## Engineers Comments Regarding Surface Water Drainage

<b>Application Reference:</b>	BE/44/25/PL	<b>Reviewer Reference:</b>	ADC/PC
<b>Planning Officer:</b>	Hannah Kersley	<b>Date of Review:</b>	31/07/2025 & 04/11/2025
<b>Site Name:</b>	Land adjacent to 21 Greencourt Drive Bersted PO21 5EU		
<b>Application Description:</b>	2 No 2 bedroom detached bungalows with associated car parking and bin and bike stores (resubmission following BE/70/24/PL. This application is in CIL Zone 4 and is CIL Liable as new dwellings.		
<b>Assessment Number:</b>	1 of 1

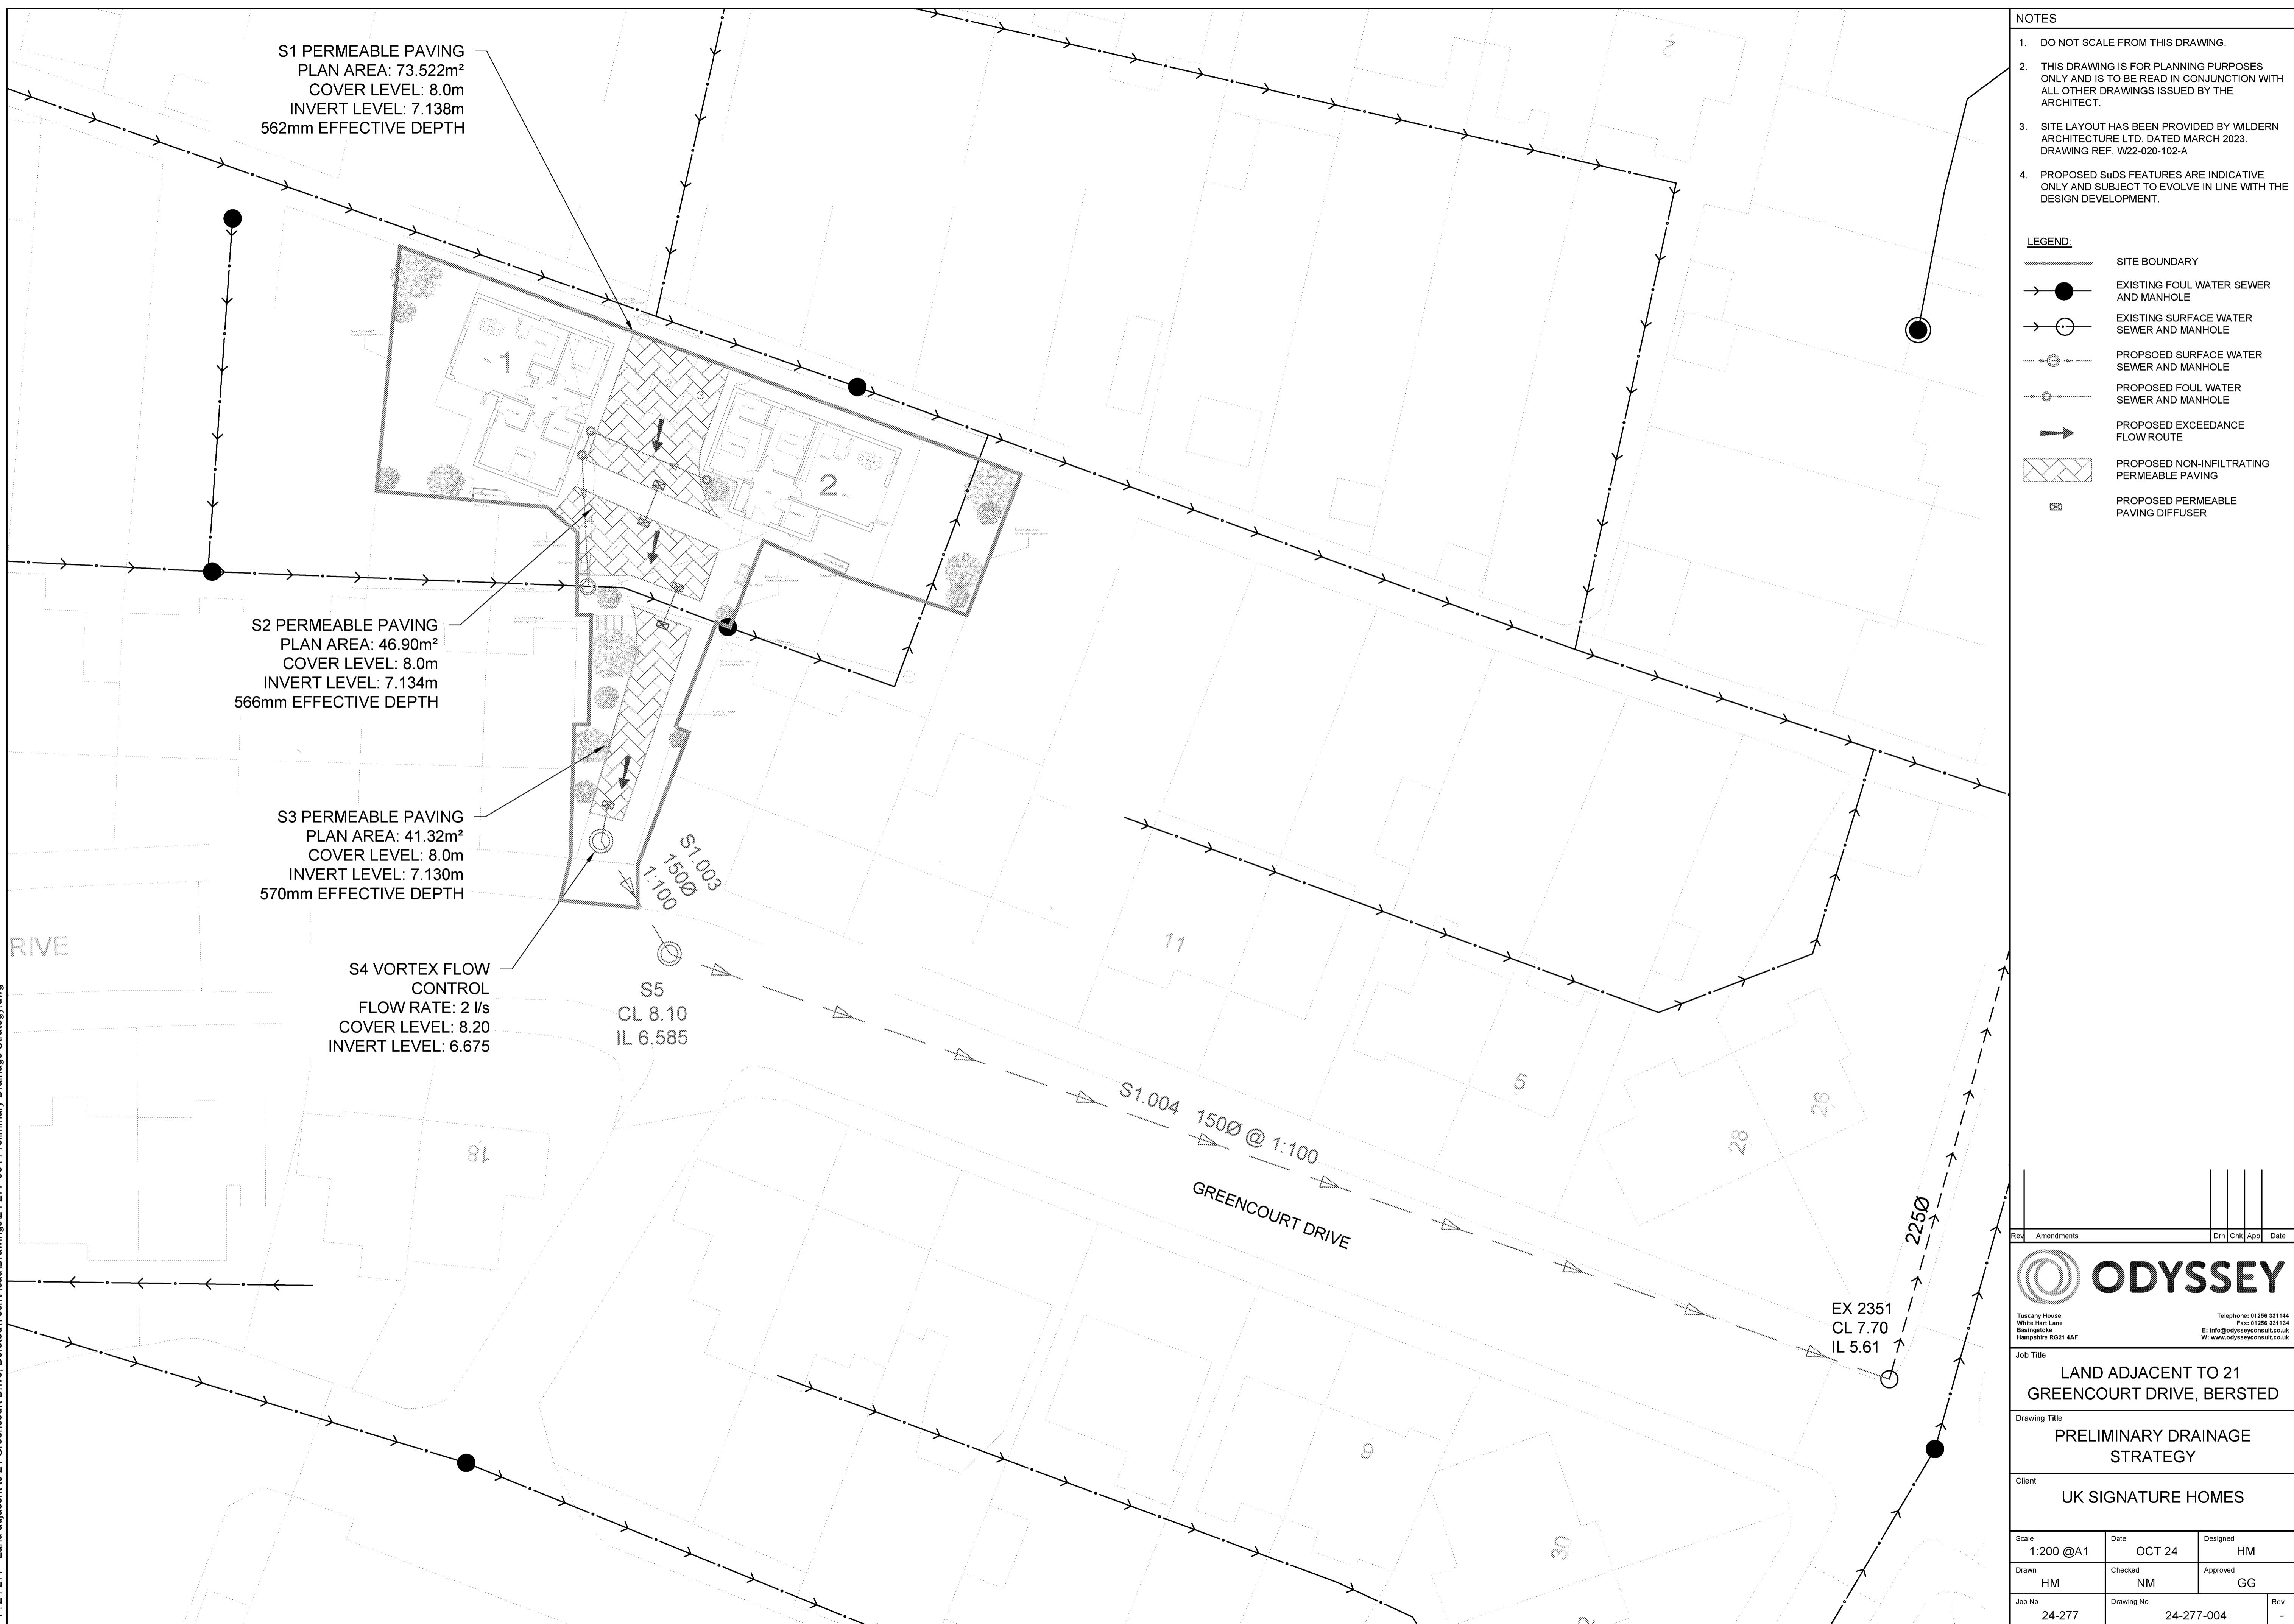
3. The applicant should note that the existing manhole being connected to at the junction of Greencourt Drive and South Way may be at a slightly different location to that shown on the drainage layout plan ie. more into the footpath. Also, it would be advisable to ensure that no third party utility mains/services, including the existing highway drainage in Greencourt Drive, conflict with the routing and levels of the proposed pipework, etc. This matters may result in having to reconfigure the proposed offsite pipework to enable a suitable connection.

**Unresolved – no response received – see image below of the actual manhole position.**

4. It is noted that there will be a considerable length of 'offsite' pipework and associated manhole/s. Confirmation is required as to whether these assets are to be adopted by a Water Company. Evidence of agreement in principle from the Water Company will be required. It is unlikely, that West Sussex County Council (WSCC), as Highway Authority will permit an unadopted arrangement in the public highway and therefore it is important to establish its future status. If adoption is not sought, then confirmation will be required from WSCC that the principle of the arrangement is acceptable to them. **Unresolved – no response/evidence received**

**The proposed pipe network around the two properties should be included in the hydraulic model.**
